From: Sue Howell
Sent: 18 October 2016 12:05
To: Planning.Responses; Hilary Kernohan
Cc: Claire Potts
Subject: FW: Planning Consultation on: LU/234/16/RES

Comment from Greenspace

APPLICATION LU/234/16/RES

Description of Works: Application for reserved matters relating to access, appearance, landscaping, layout and scale of the previously approved LU/63/11/. This application affects a Public Right of Way

Plant schedule

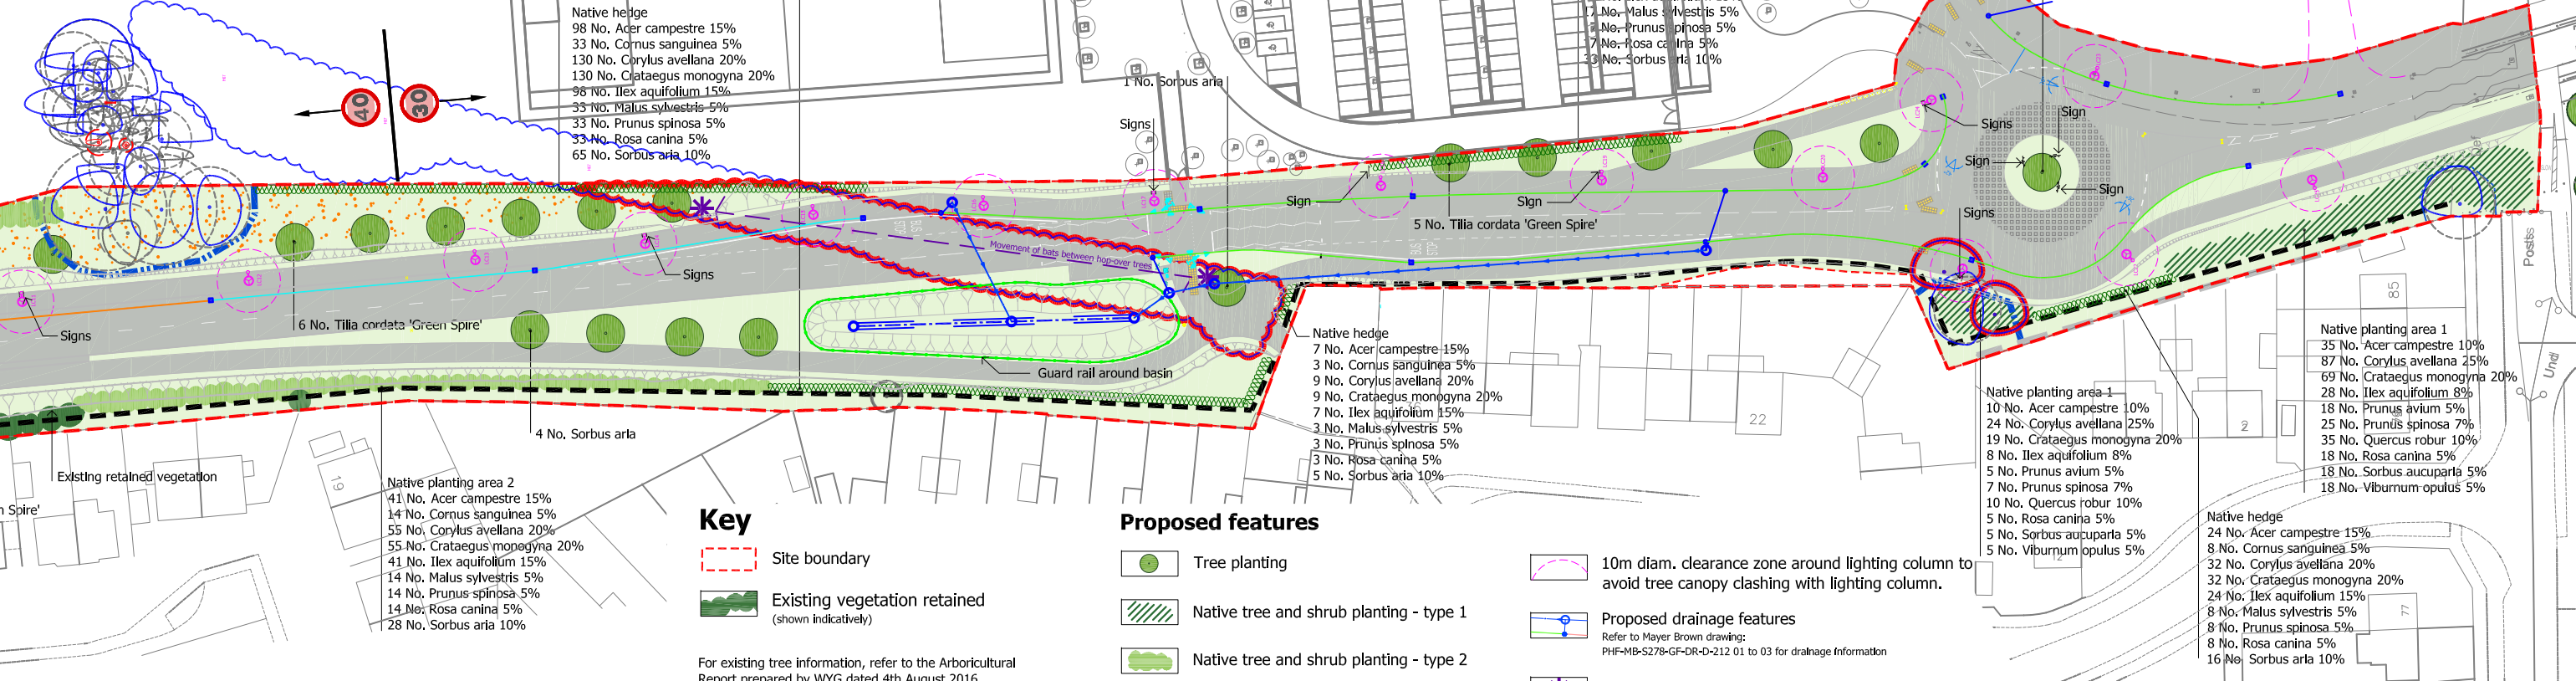
The landscape scheme proposed under this reserved matters application contained in drawings A008461 FL1&2 (C) in general provides a good species selection of mixed native evergreen and deciduous trees and shrubs, which if given the correct protection and aftercare would create a suitable scheme. The details show proposed planting located particularly to the west of the proposals adjoining the existing housing, which when established with the existing retained vegetation will provide screening and buffer zone benefits in this area. The semi mature tree detail re species choice, sizes and location of planting we feel is adequate for the location in that over time it will help soften the proposals into the surrounding landscaping providing a greening along this roadway. The tree species chosen will produce trees with a reasonably compact head form which obviously has been considered in relation to spread, sight lines and street lighting. Generally a mix of species would be preferred to give greater biodiversity to the scheme however the tree sizes indicated will provide instant impact and will help to mitigate for those lost within the proposals.

Whilst there is a good spread of amenity trees at a semi mature size incorporated into the scheme to both sides of the proposals the understory native planting is proposed predominantly to the western side. Consideration should also be given to the eastern aspect which adjoins the school, where the proposals are presently inadequate, it would be advised that understory natives should also be incorporated along this edge and to the open areas where landscaping was indicated in the original LU/63/11 application. Screening to this eastern aspect is required and also consideration given to the views beyond, the formation of a green link and habitat corridor to this fringe of the proposals being required.

Clarification should be provided on the landscape layout plans as to the spacing of the native transplant planting being proposed so that a clear picture of proposed density and how quickly this will establish can be seen.

Protection measures along with a comprehensive maintenance regime would need to be in place to ensure that the planting does establish, thrive and develop to the screen suggested. This would be particularly relevant to the semi mature trees being proposed which would form an important statement along these proposals. The future long term maintenance should also be considered post establishment regarding the tree protection methods initially employed, these will require a strategy in place for their ultimate removal once no longer required and before they become a litter issue and hazard.

We would not recommend approval of reserved matters relating to Landscaping following outline consent LU/63/11/ under this application LU/342/16/RES until the above has been submitted and approved.
